CITY OF ALBUQUERQUE
PLANNING DEPARTMENT
DEVELOPMENT REVIEW BOARD

Project# 1010010

14DRB-70269 MINOR - PRELIMINARY/ FINAL PLAT APPROVAL
15DRB-70233 SUB DESIGN/ SIDEWALK VARIANCE

RE: Lots 19-20, Block 4, North Albuquerque Acres Tr. 3, Unit 3

PROJECT: 1010010
 DATE: 8-6-14
 APP: 14-70269 (P&F)

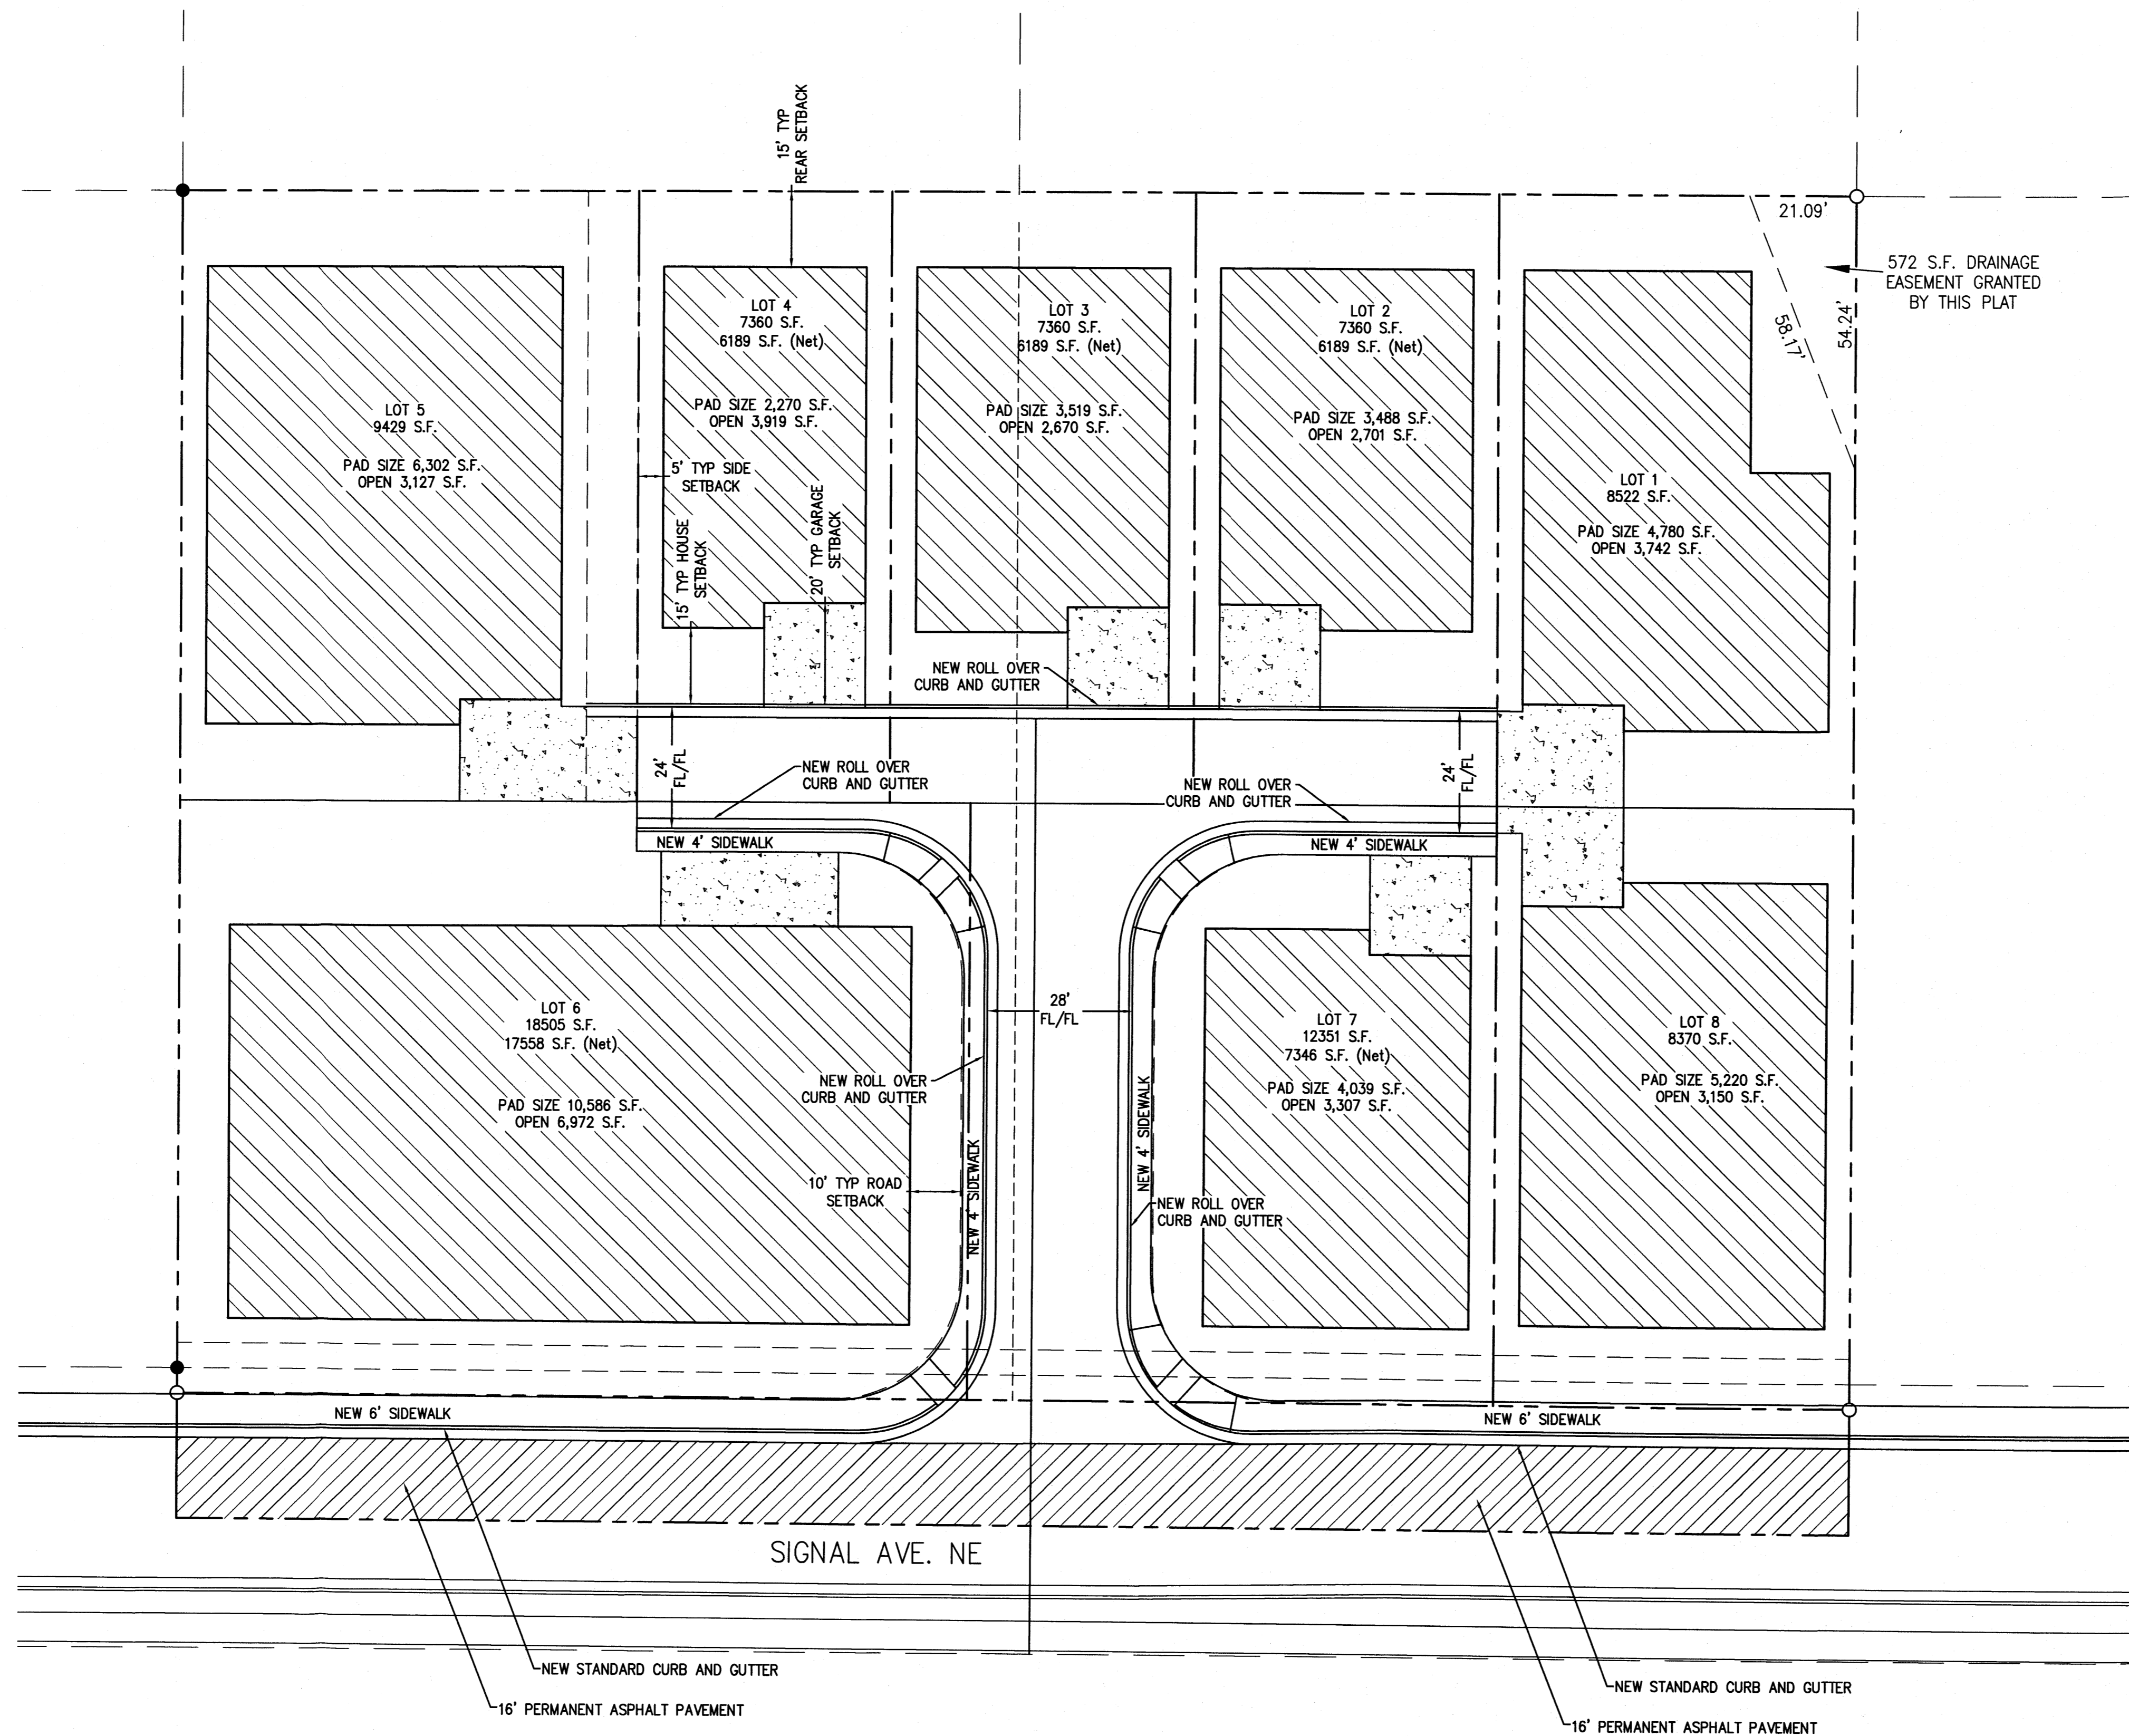
Please remove 'zoning' notes (2 and 7) from final plat.
It appears an Infrastructure List is needed; refer to comments from
Hydrology, ABCWUA and Transportation.

PROJECT: 1010010
DATE: 7-8-15
APP: 15-70233 (SV)

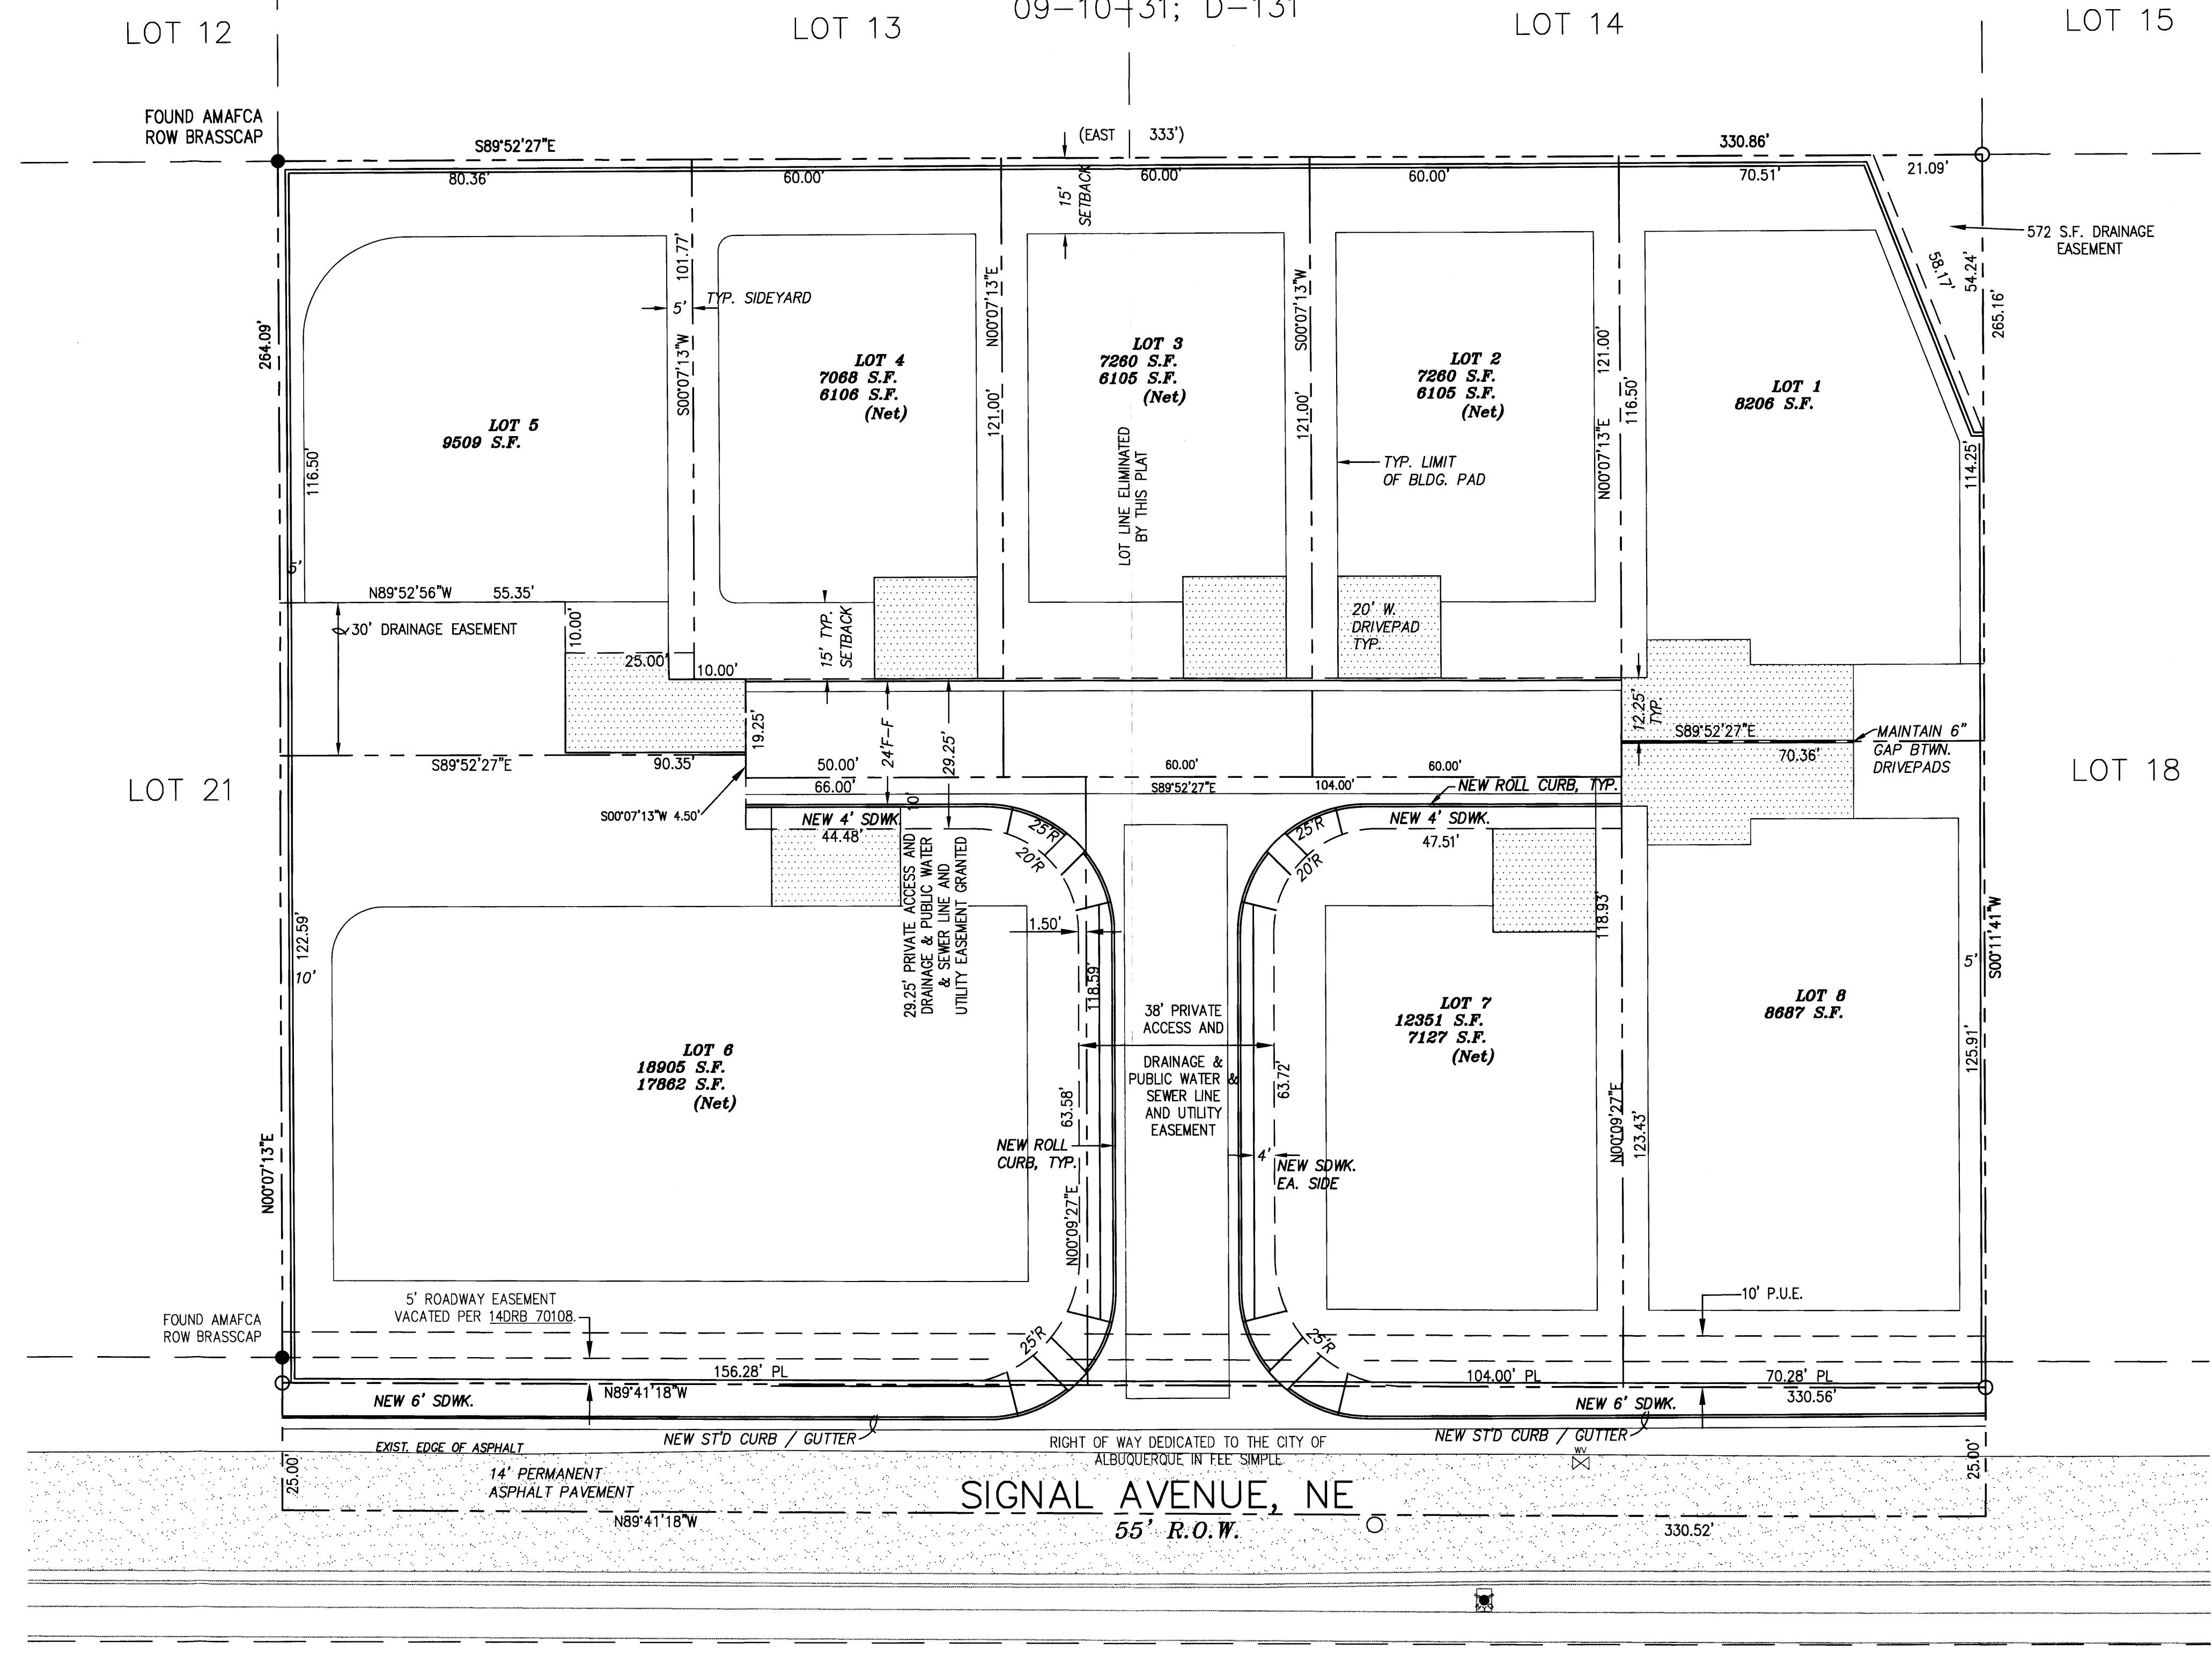
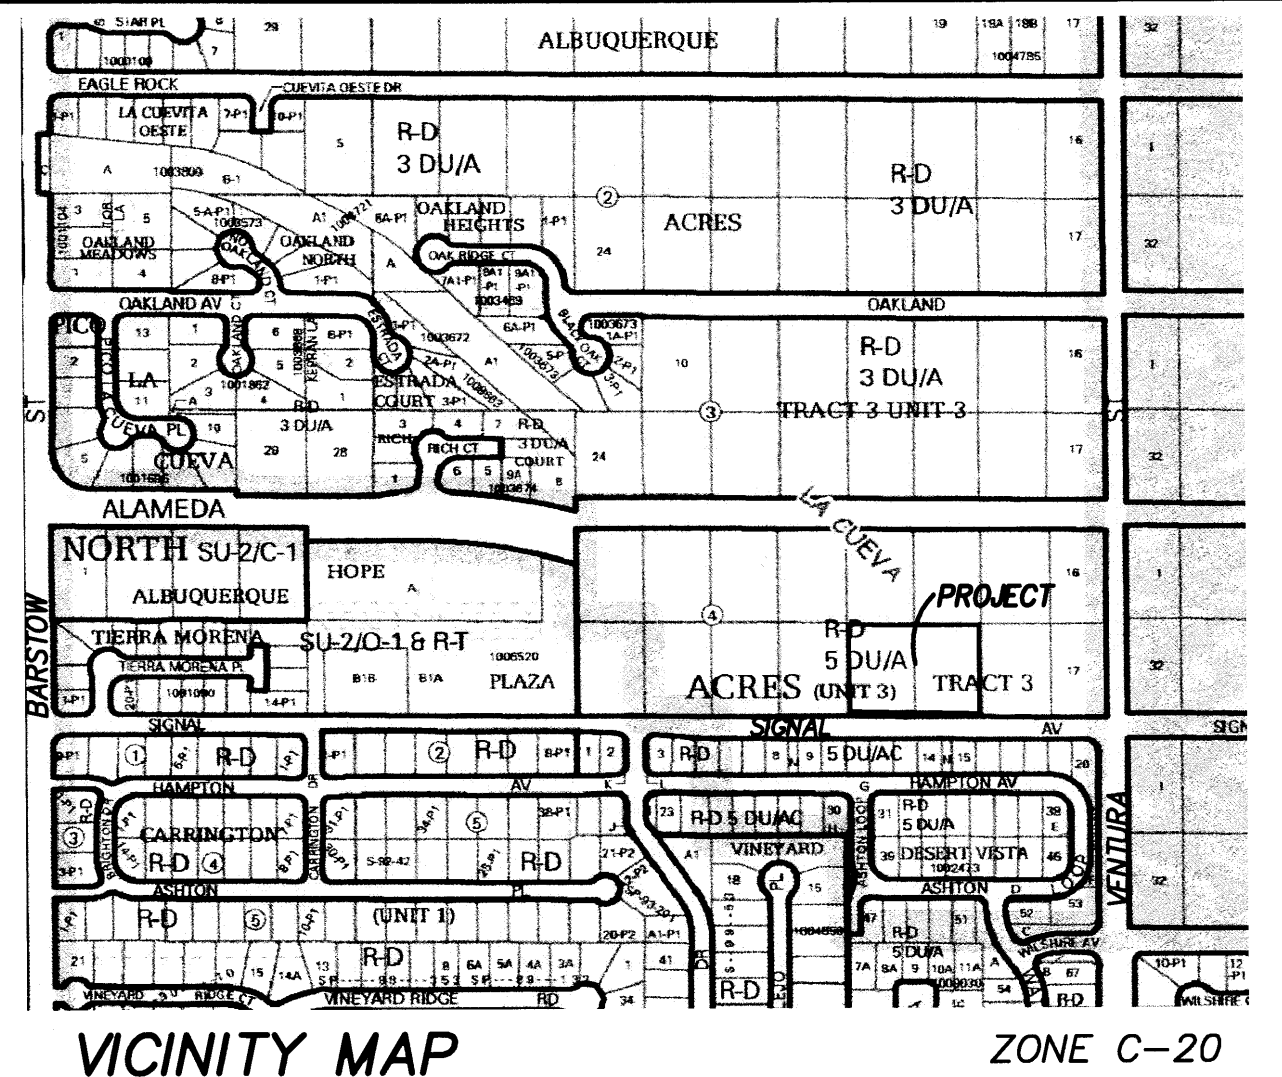
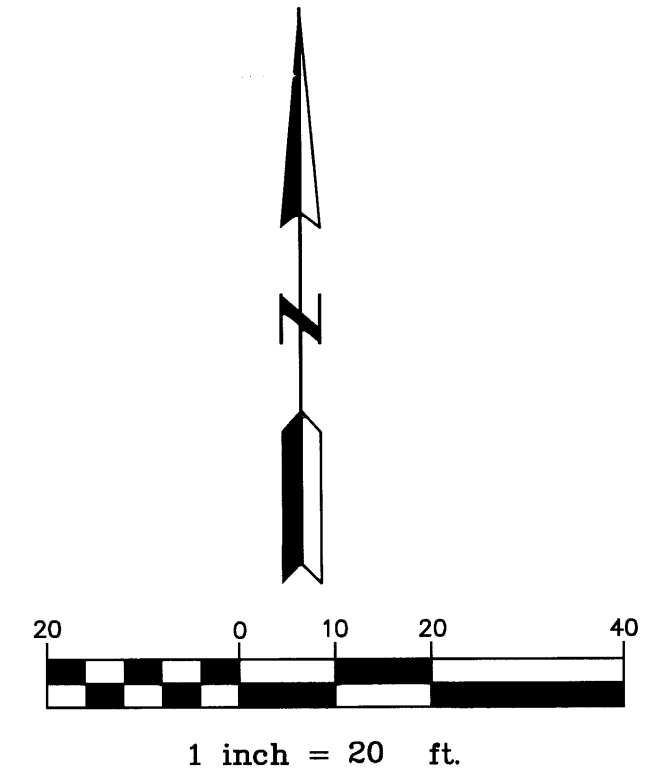
A subdivision design variance for a waiver of sidewalk on the north side of the private interior street was approved as shown on exhibit in the planning file, based on the lack of connection to other sidewalks.
